**Transport
for NSW**

Re: Glebe Island Expo: Temporary International Convention, Exhibition and Entertainment Facility at Somerville Road, Glebe Island – Response to public exhibition

CAR PARK A
SCALE 1:1000

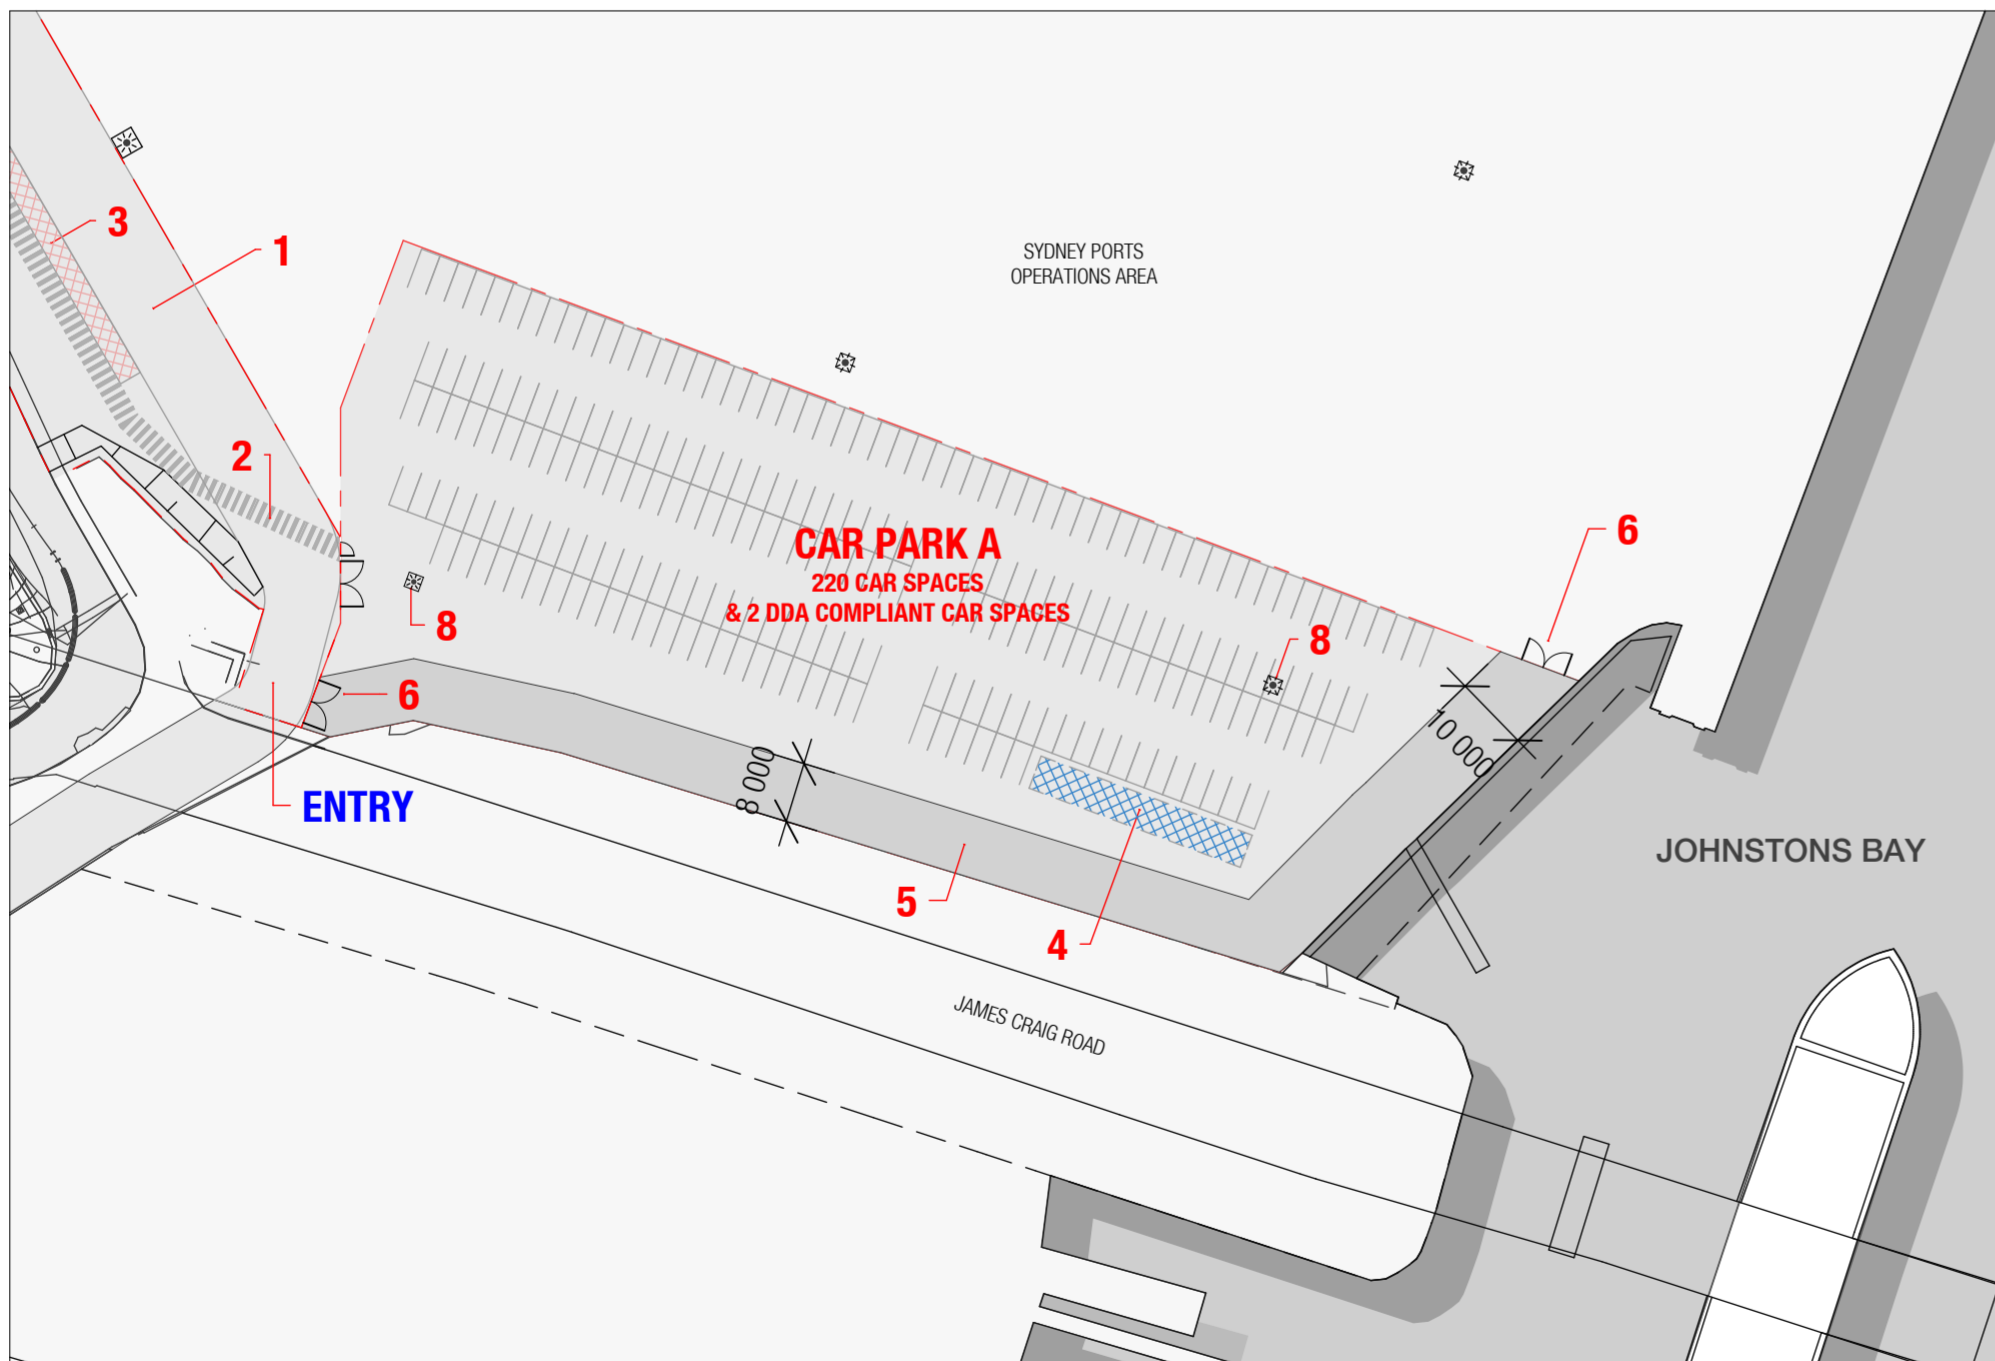
We further note that Figure 27 of the EIS shows car parks A-D. Car park A is located in an area which may be suitable for short to medium term recreational boating uses in support of the Government's policy commitment to increase access to waterways. Until the outcome of the Bays Precinct Taskforce is finalised, it is requested that DP&I liaise with OBSMA regarding the potential use of the land in and adjacent to car park A as shown **[Attachment A]**.
